**FINAL DRAINAGE REPORT  
FOR  
TAMLIN ROAD RV STORAGE-EXPANSION  
EL PASO COUNTY, COLORADO**

December 2024

PCD File No.: PPR2437

PROPOSED DRAINAGE MAP  
 TAMLIN RD RV STORAGE-EXPANSION  
 JOB NO. 25305.00  
 11/26/2024  
 SHEET 1 OF 1

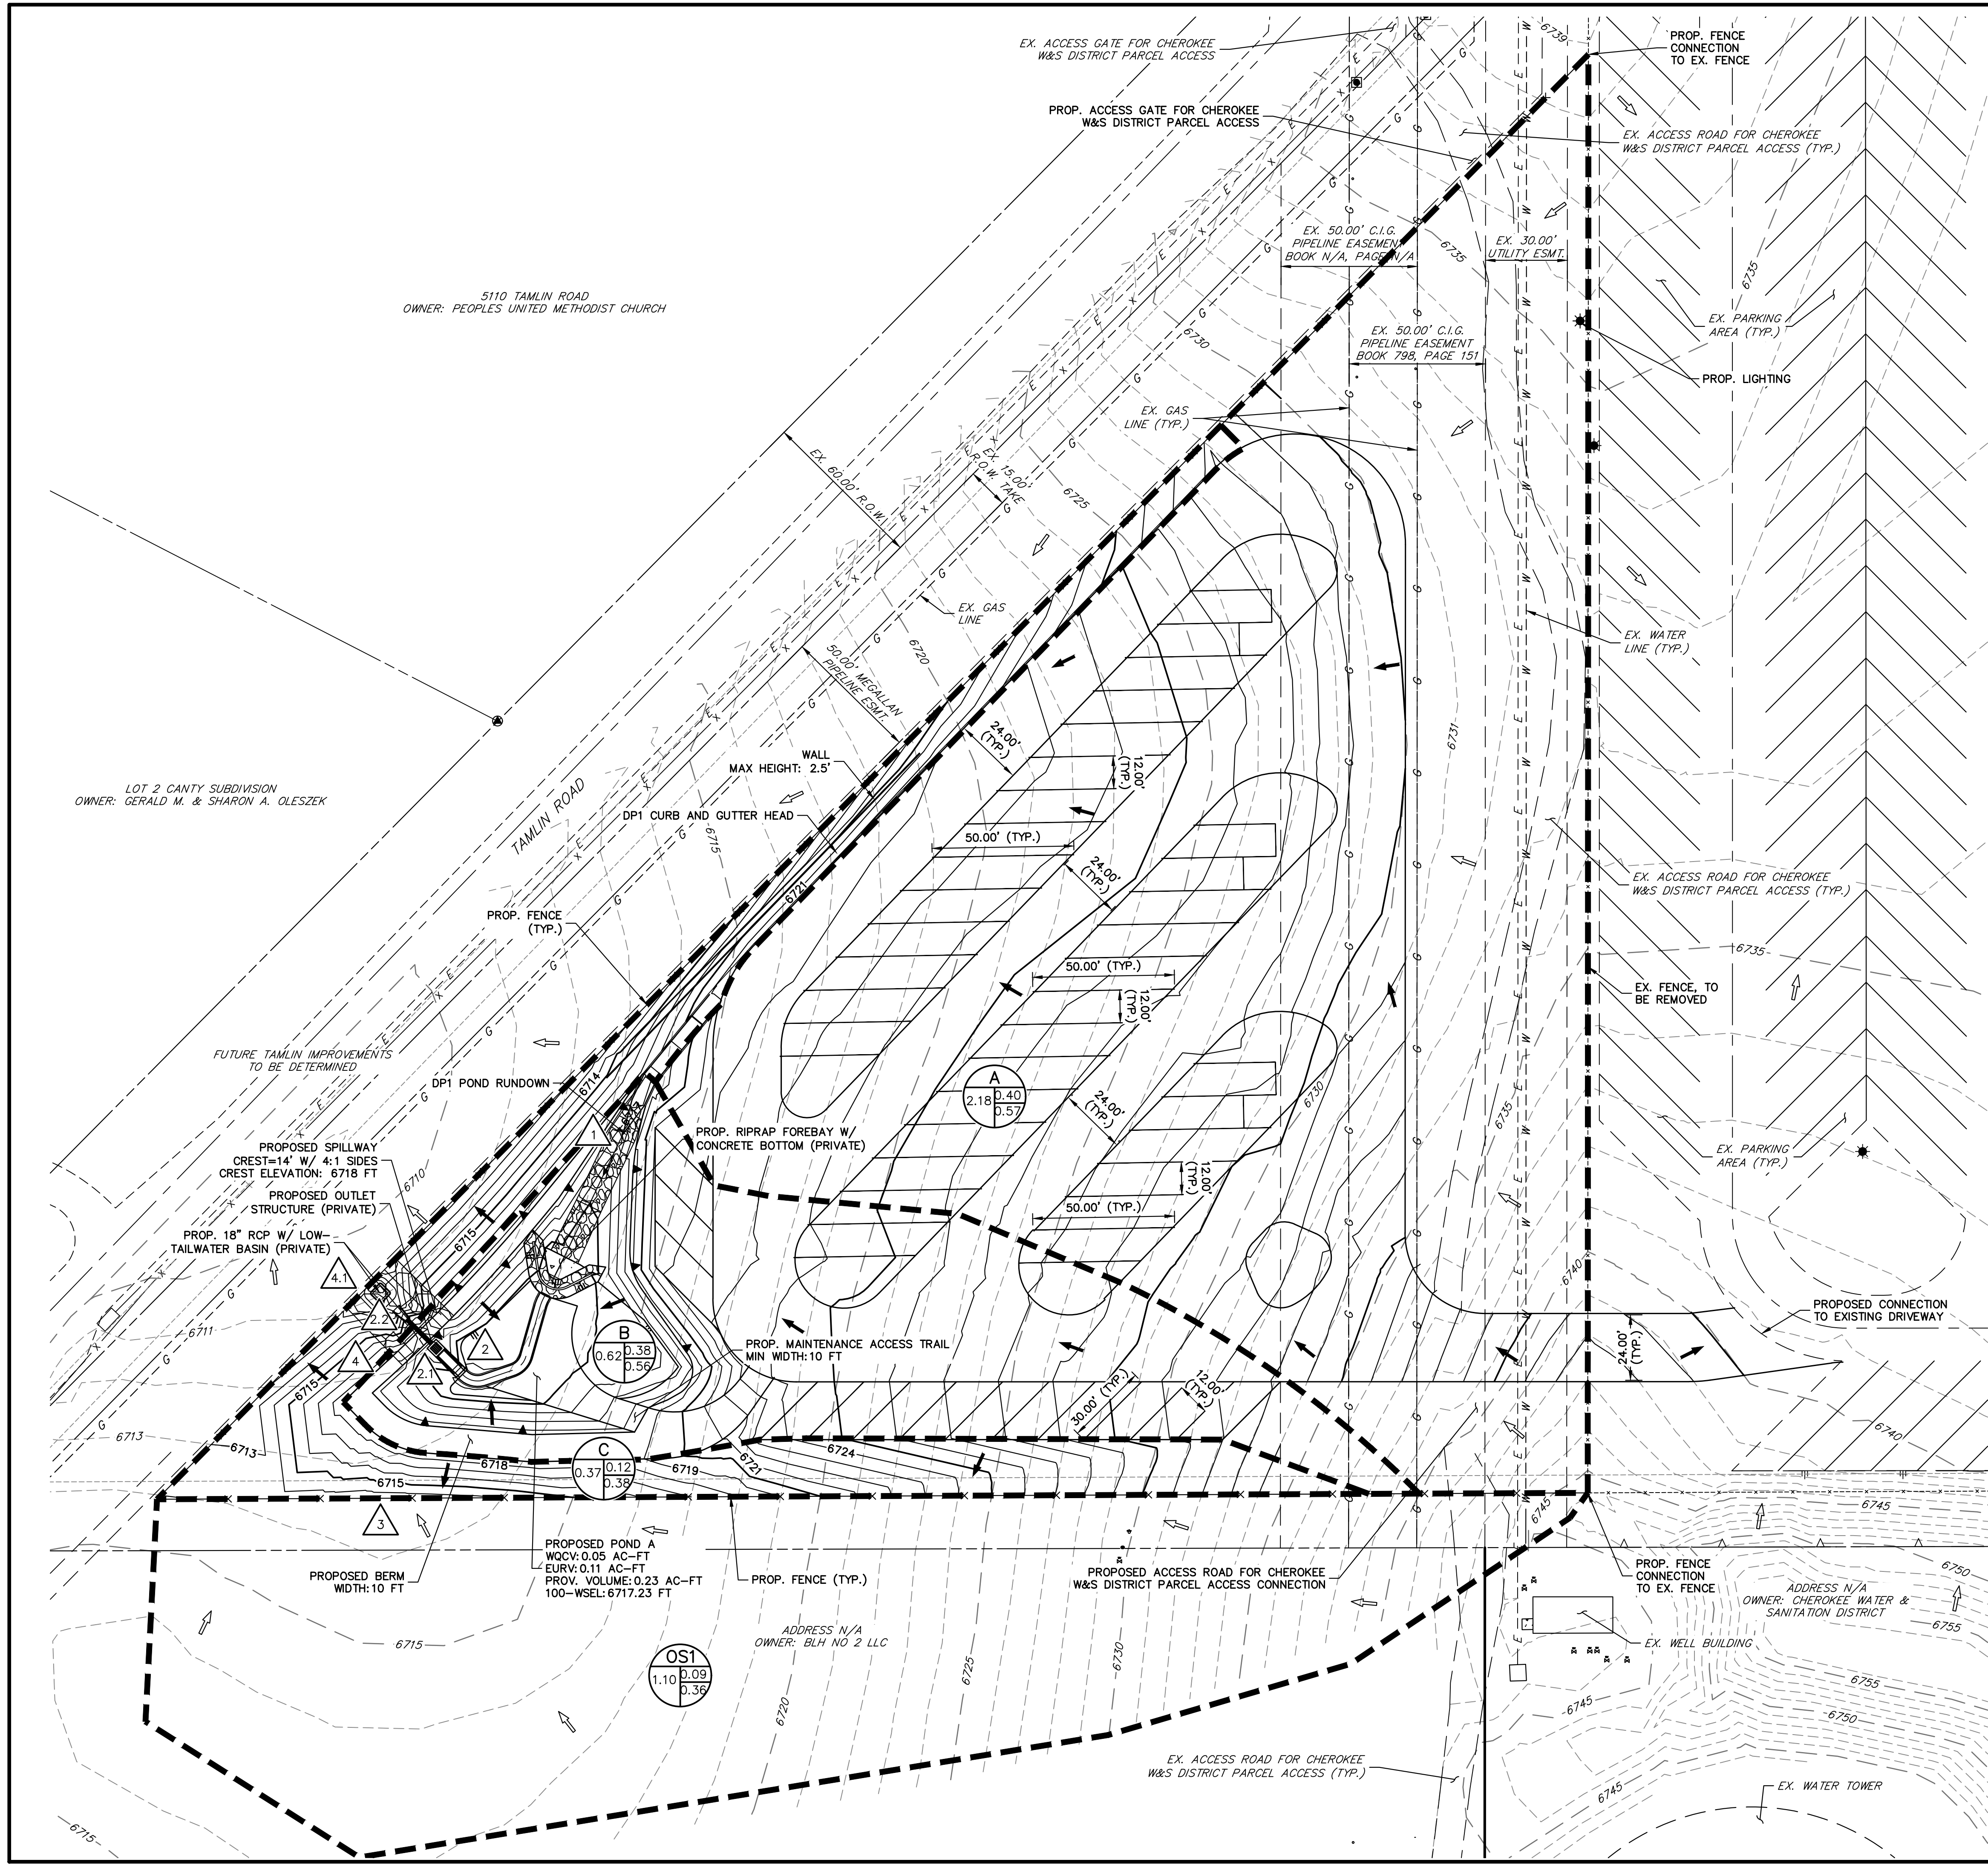
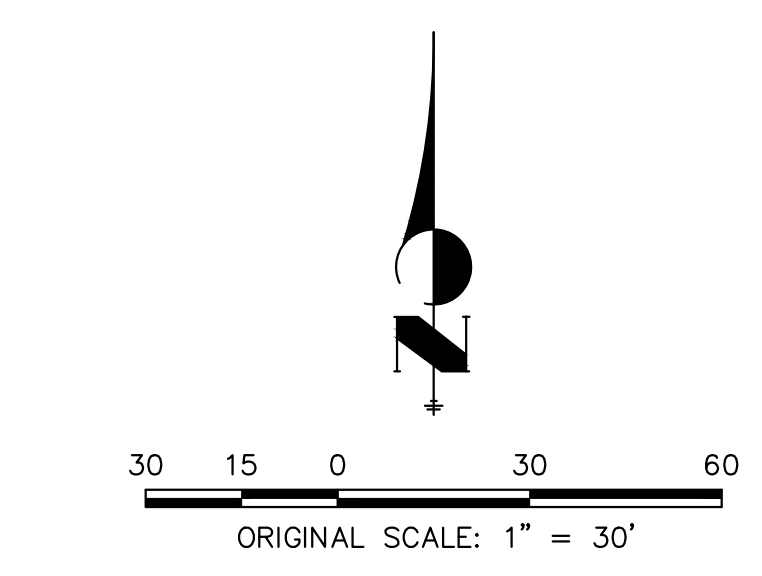
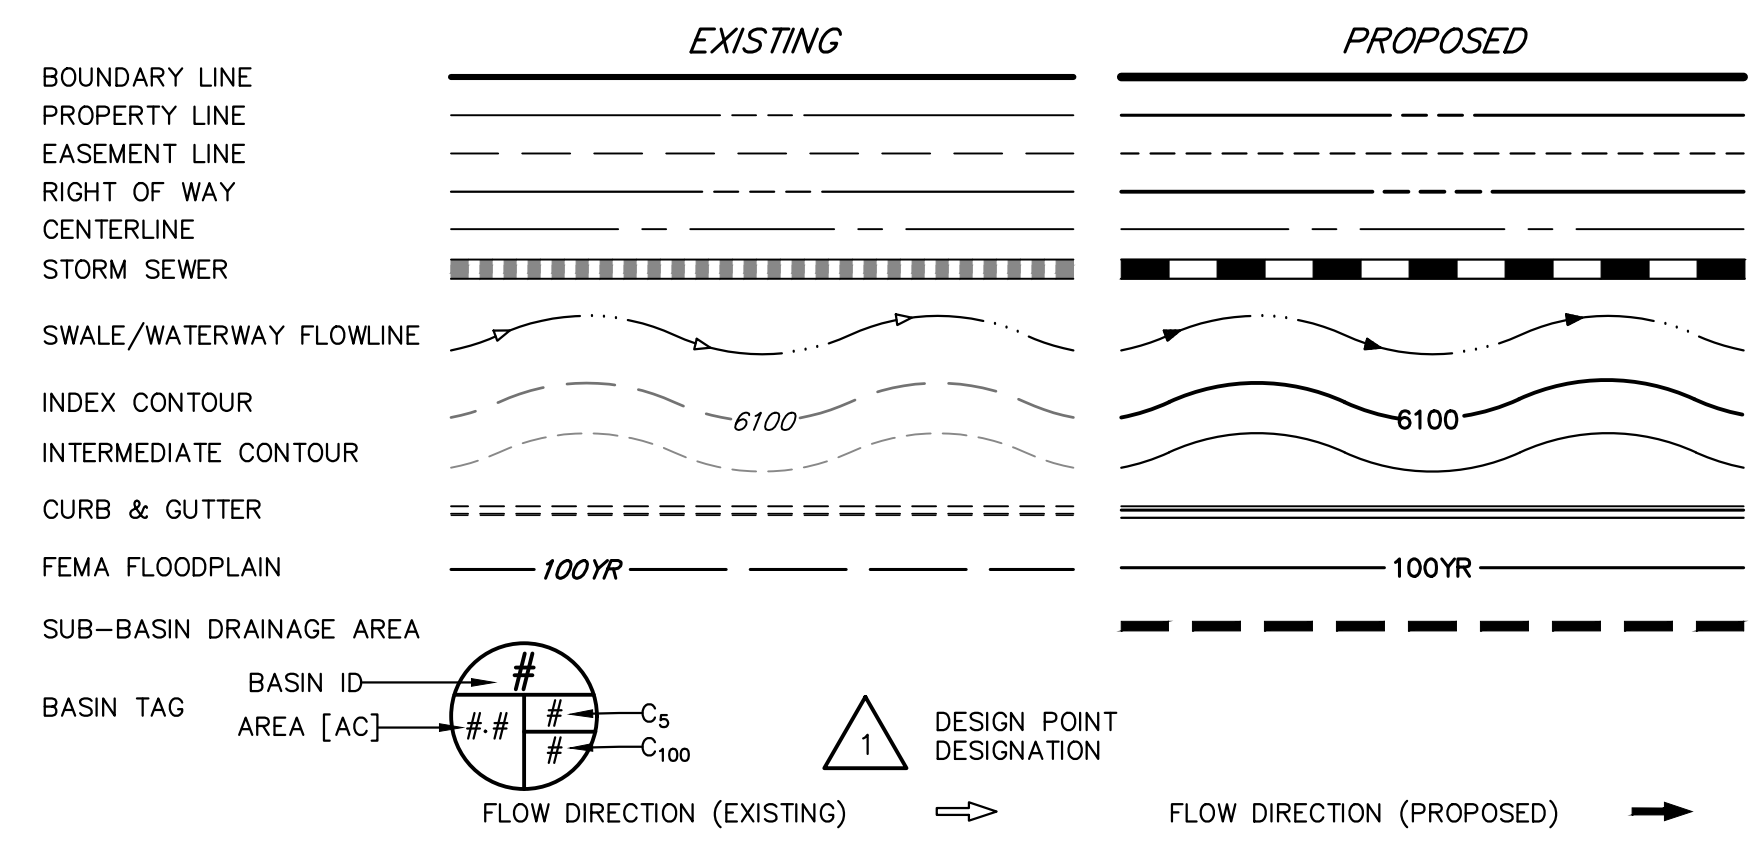
Discuss where the suitable outfall is located beyond Tamlin. Explain if there is roadside swale that can adequately convey outfall out of the stiling basin and where the flow goes
